**From:** Neville, Julie <Julie.Neville@lancashire.gov.uk>  
**Sent:** 19 June 2025 18:32  
**To:** Planning  
**Subject:** 3/2025/0346 Dowsons Dairies Ltd Hawkshaw Farm Longsight Road Clayton le Dale BB2 7JA  
**Attachments:** PROW S119 Overlay.pdf

**Reference** 3/2025/0346  
**Location** Dowsons Dairies Ltd Hawkshaw Farm Longsight Road Clayton le Dale BB2 7JA  
**Proposal** Change of use of agricultural land to create an additional 95 car parking spaces

<b>Mr &amp; Mrs Dowson</b>	
Hawkshaw Farm Park, Longsight Road	
<b>Proposed Site Level Plan</b>	
Dwg No.	Rev.
A3876-PL25	
Scale	Sheet Size
1:500	A2
Date	
May 2025	
Drawn	Checked
DME	Approved

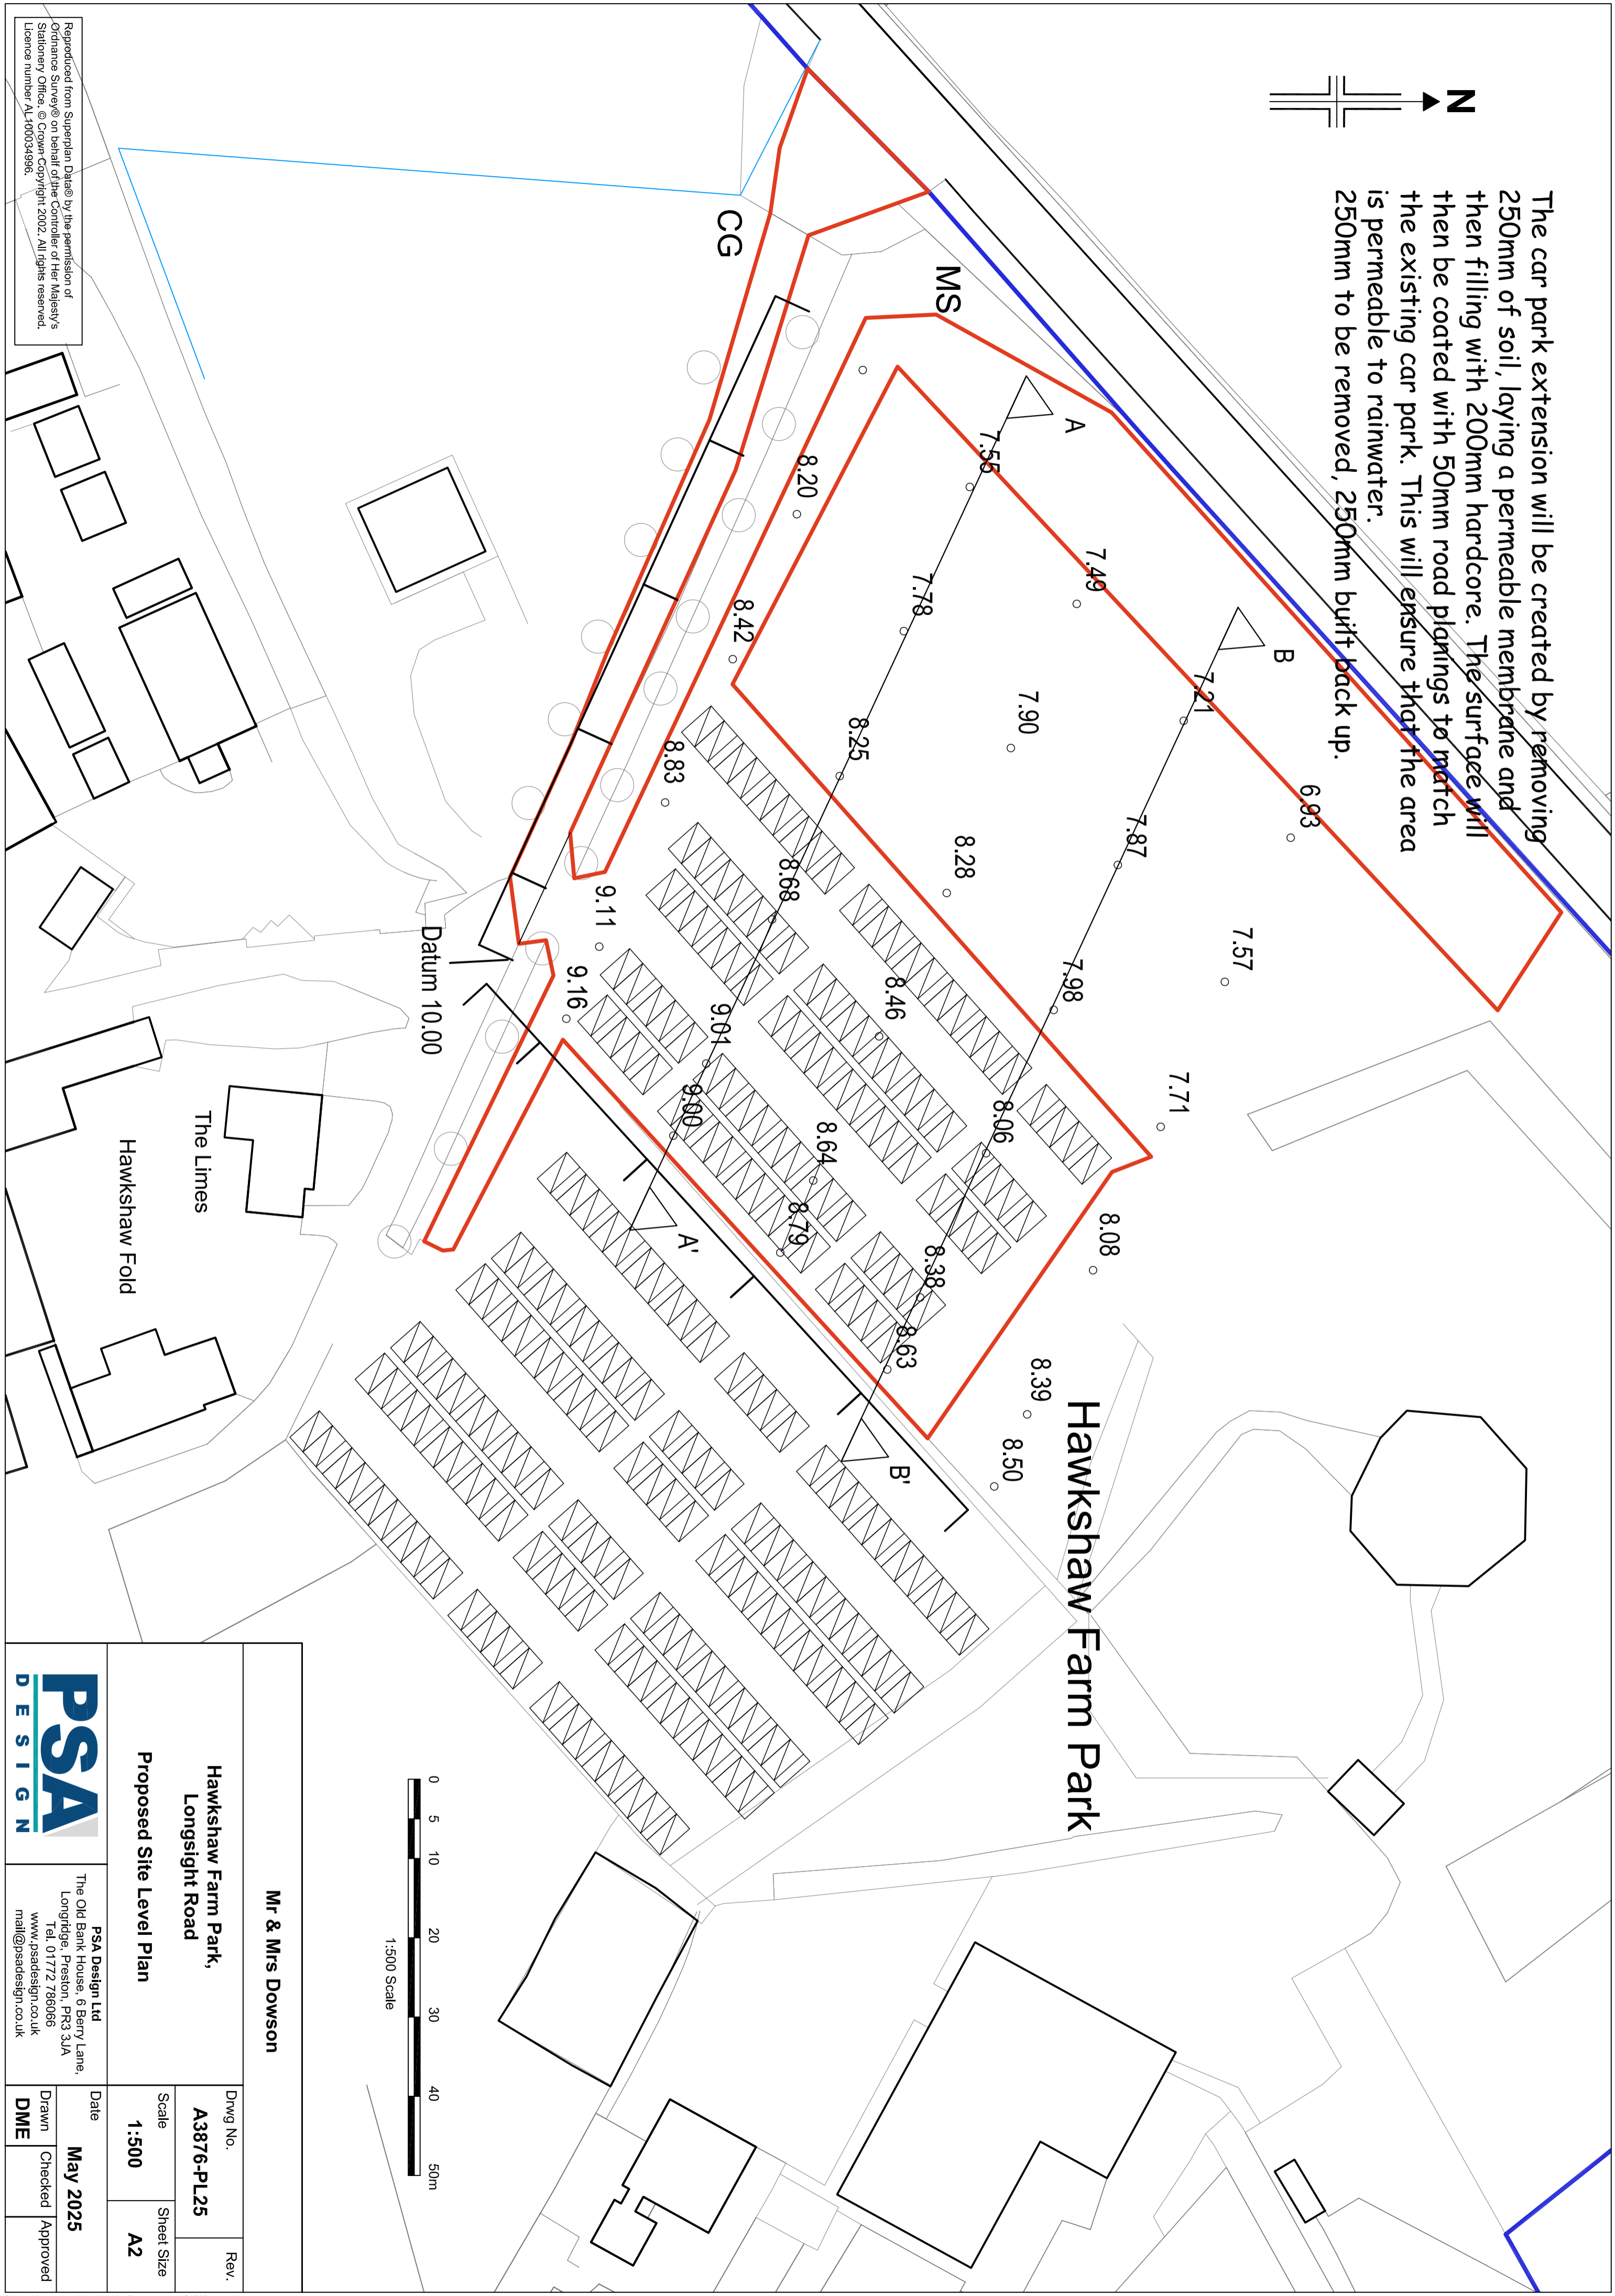
Any changes in ground level or installation of drainage should ensure that surface water is not discharged onto a public right of way either within the proposed development site or in close proximity – this is to ensure public rights of way are not exposed to potential flooding or future maintenance issues.

| Proposed Site Layout Plan | | Dwng No. | Rev. |

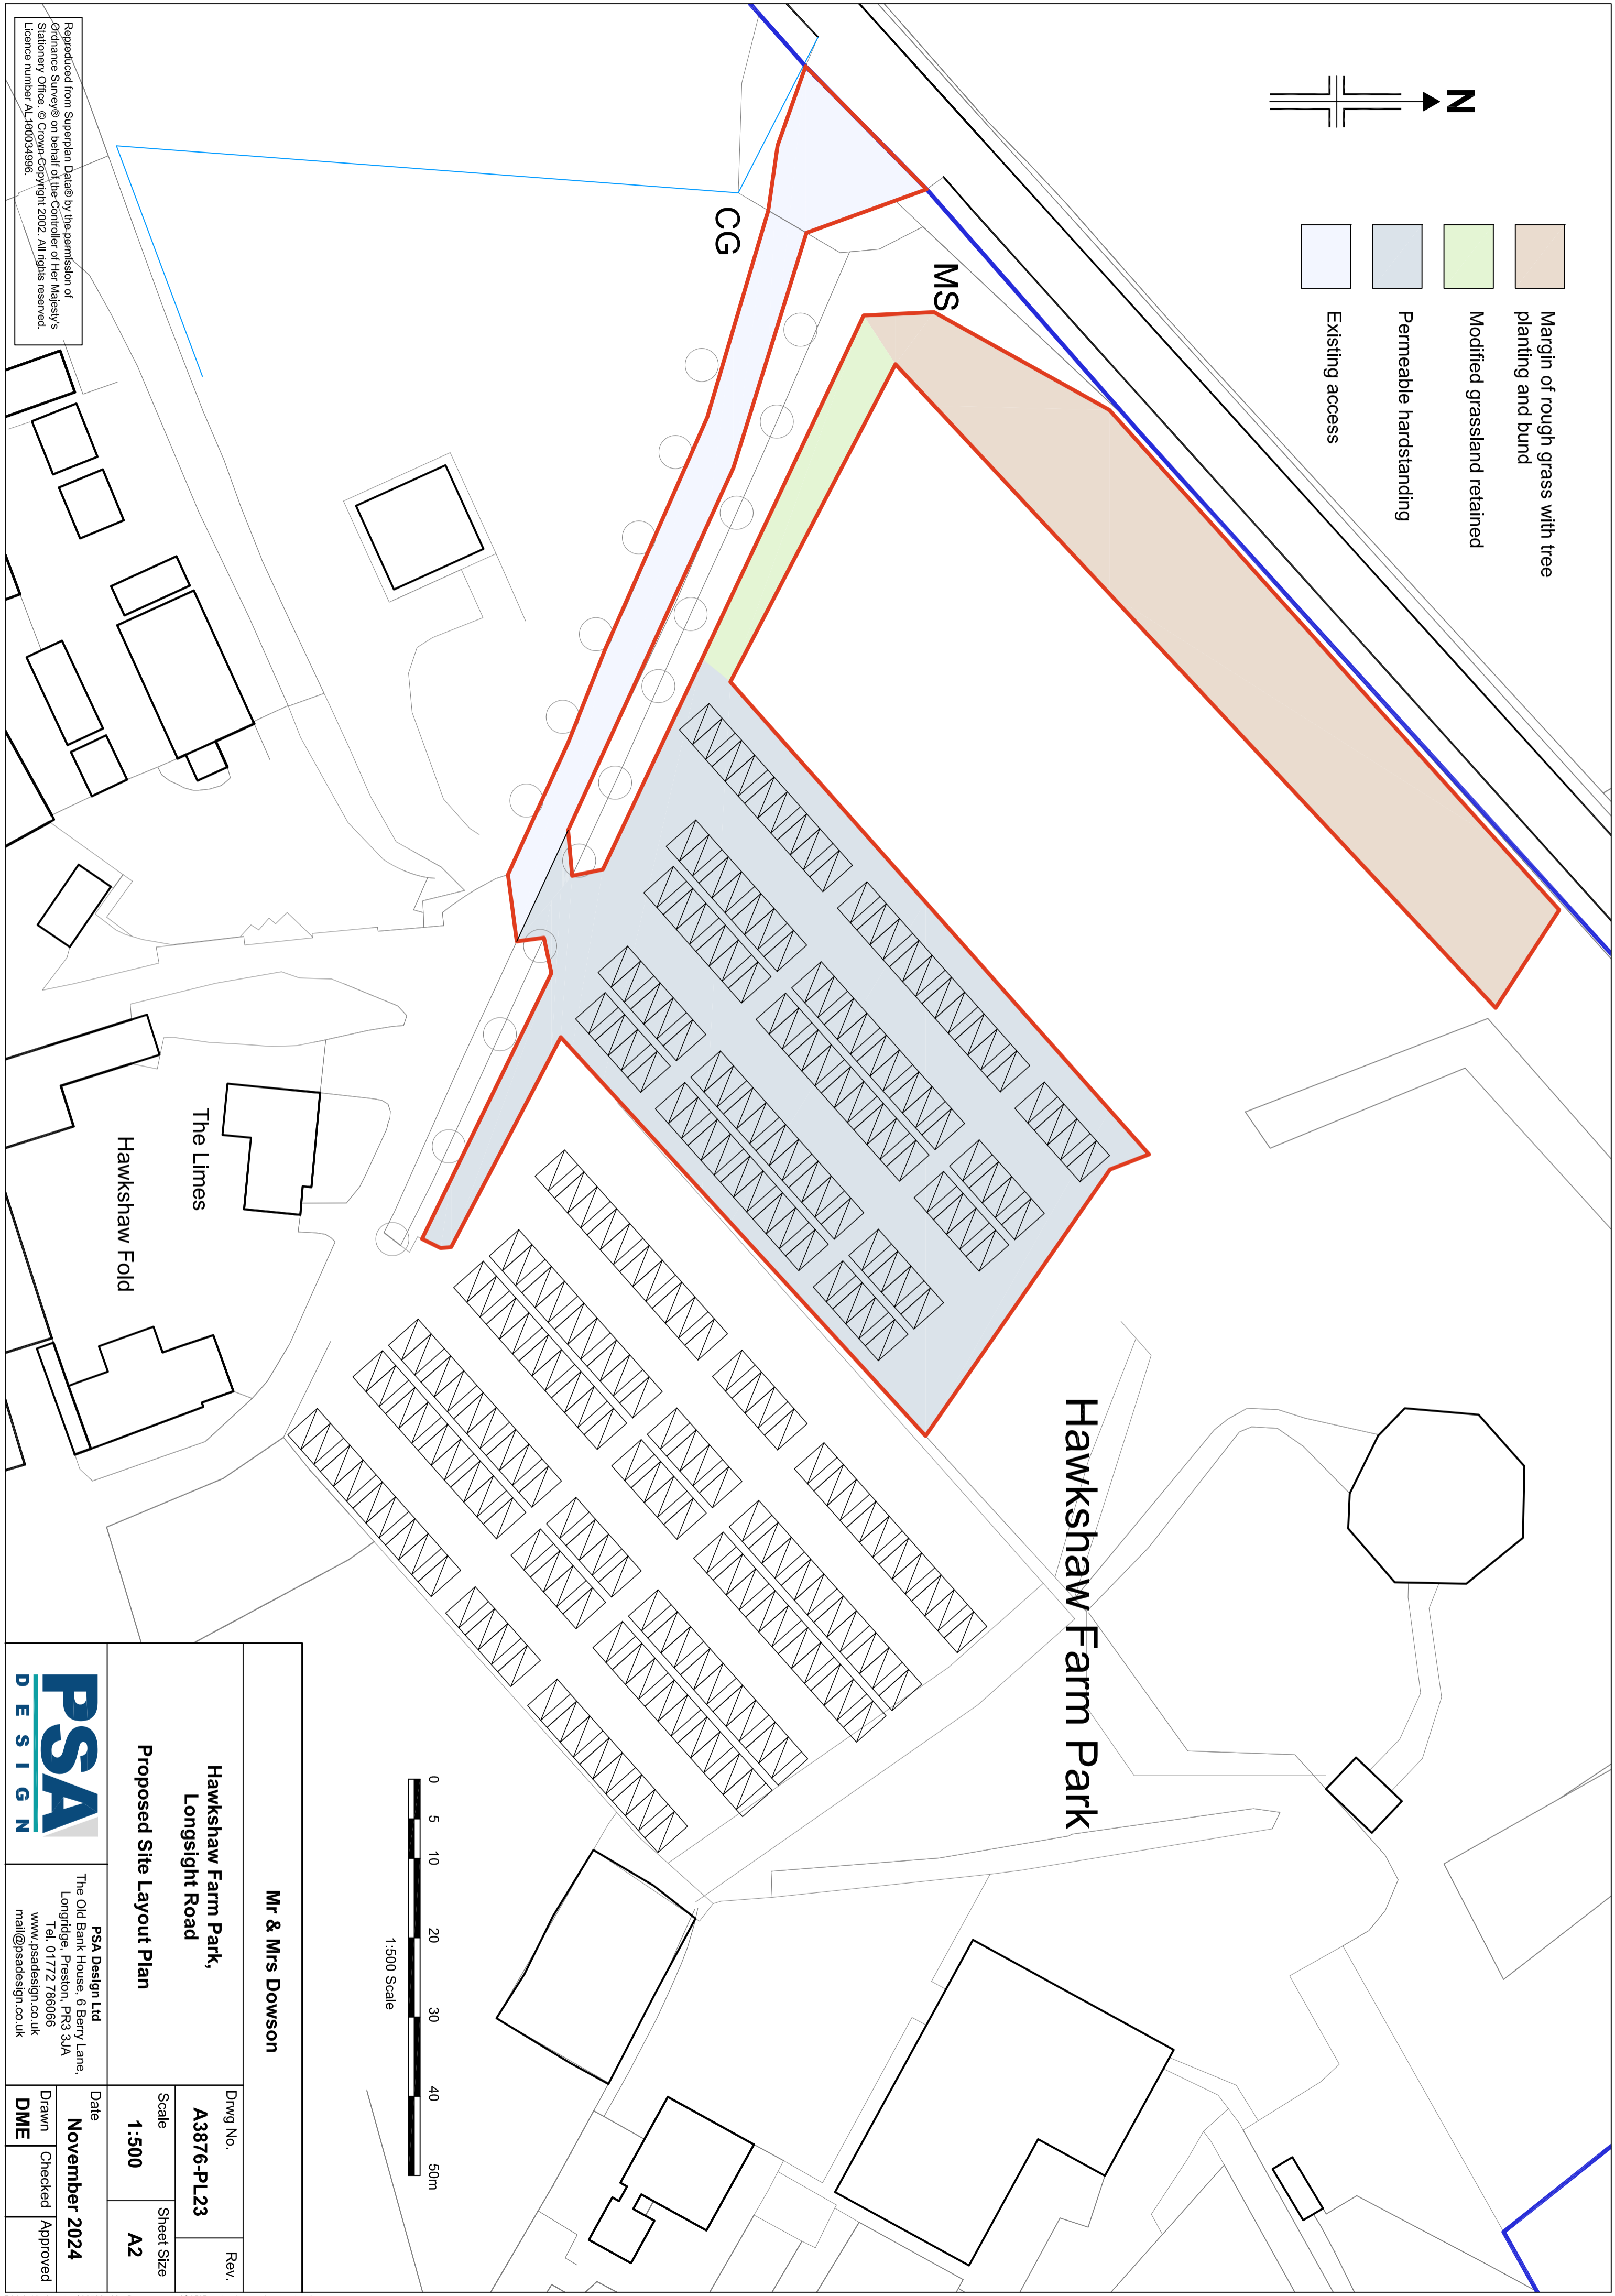
Footpath FP0313003 is recorded along the access to the parking spaces. Included within the application is a draft Order plan for the diversion of footpath FP0313003 under Section 119 of the Highways Act 1980 (HWA80 S119). Should the Order Plan be confirmed the parking spaces will conflict with the HWA80 S119, as shown on the attached plan, and as such the layout of the parking spaces requires reconfiguration to give provision for the realignment of the right of way or contact is to be made with Lancashire County Council's Public Path Order Officer to address the proposed conflict as the infringement or obstruction of a public right of way would be a criminal offence.
